**Consultation Response from KC,
Trees****2021/92462 rear of, 1091, Manchester Road, Linthwaite, Huddersfield, HD7 5LS****Outline application for erection of detached dwelling****Date Responded: 09/07/21****Responding Officer: Nick
Goddard****Responding Ref: 22/80**

STATUS			PROVISIONAL		
PROJECT			LAND OFF 1091 MANCHESTER ROAD		
TITLE			PROPOSED		
CLIENT			P.WHITING		
DRAWN BY	CHECKED BY	DATE			
Author	Checker	12.05.2021			
SCALE (@ A1)		PROJECT NUMBER			
As indicated		HD.20.33			
DRAWING NUMBER				REV	
HD.20.33.01

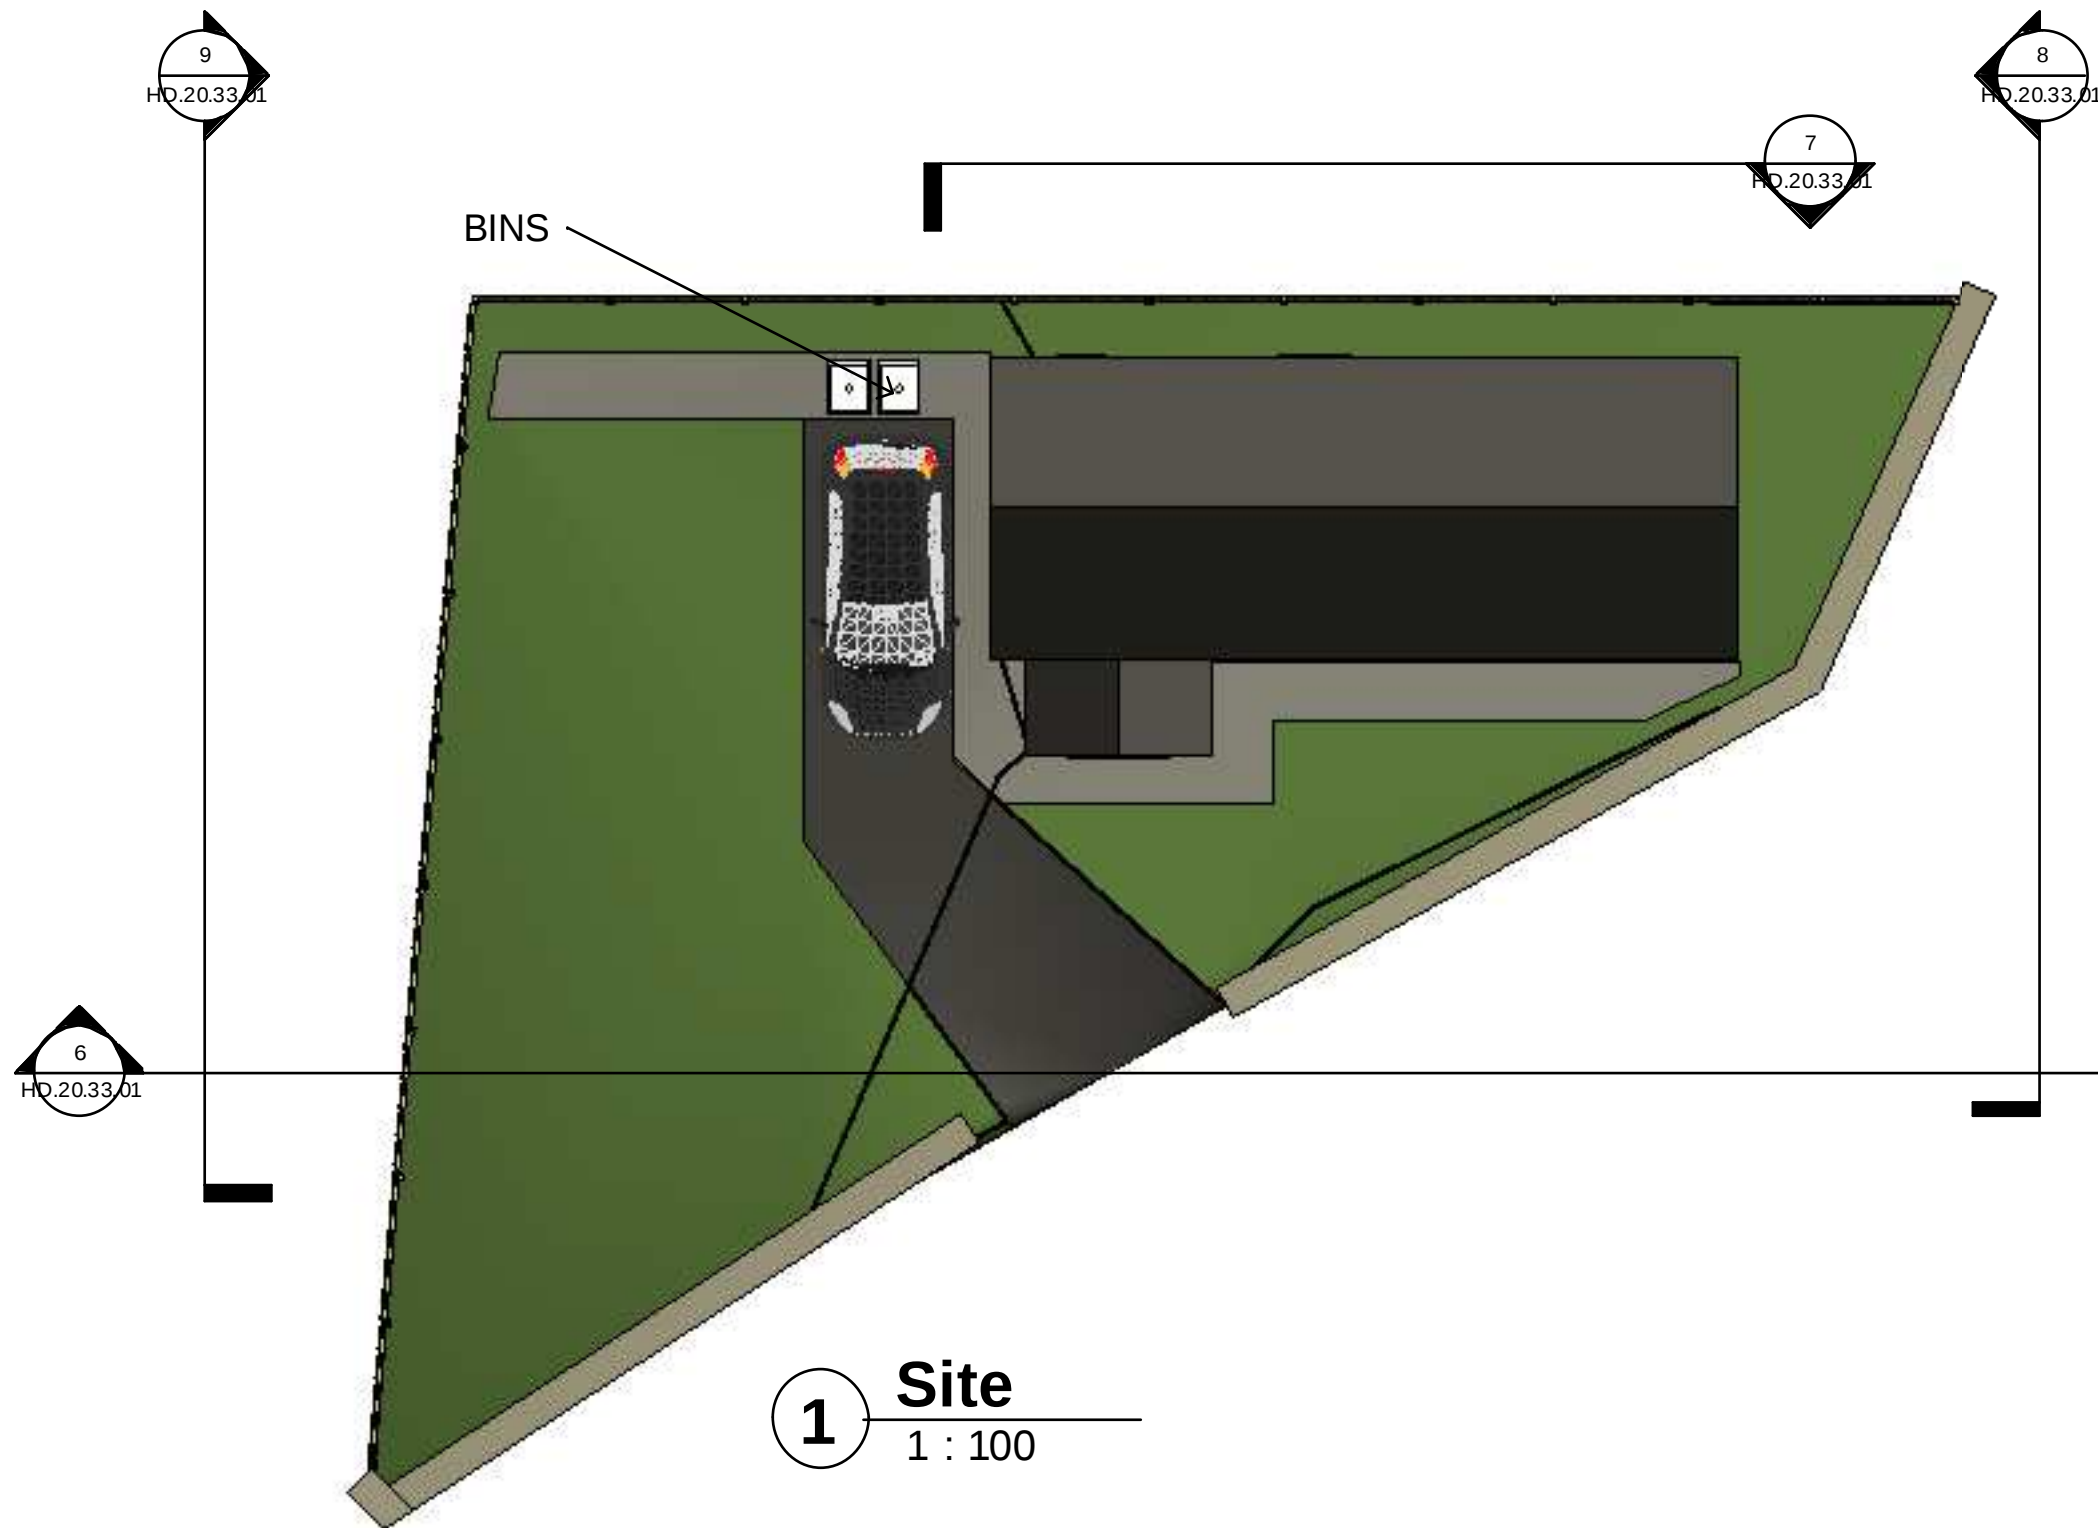
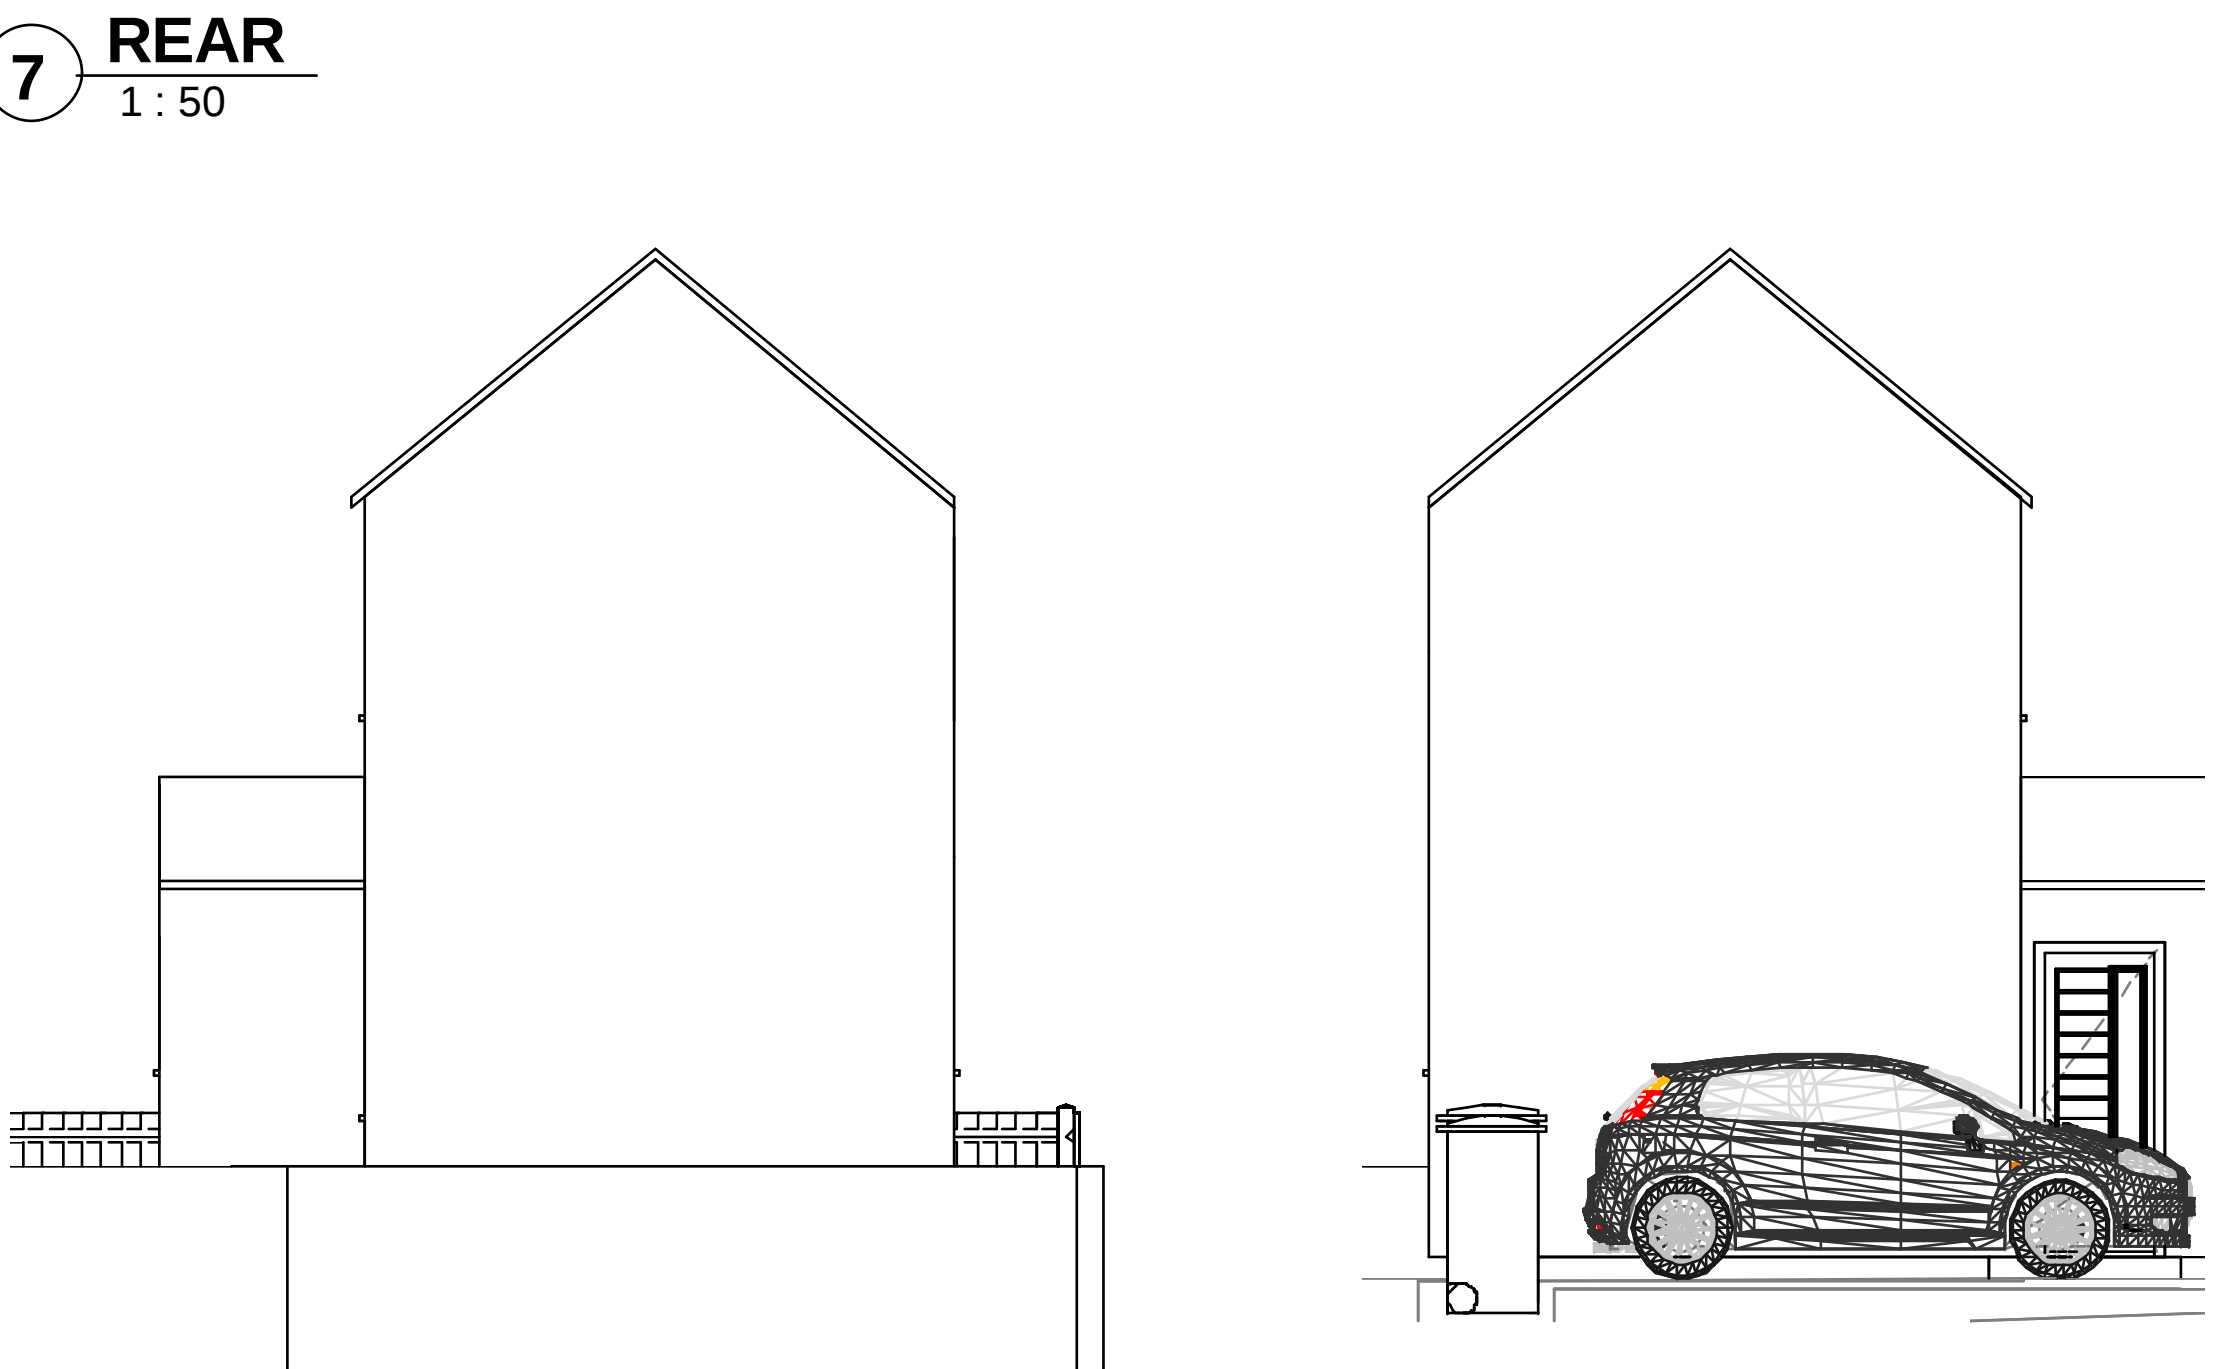
This site has a single tree TPO, ref 22/80/T1, on it. There are no protected trees on the site anymore as this protected Ash tree was removed following an application in 2006. A condition of that removal was that a replacement Hornbeam would be planted in the same place. I can see no sign of that replacement tree on site and these proposals are an opportunity to correct that.

I would have no objection to the principle of developing this site for residential use but I would advise that a Fastigate Hornbeam tree should be included on the road frontage as part of any reserved matters application.
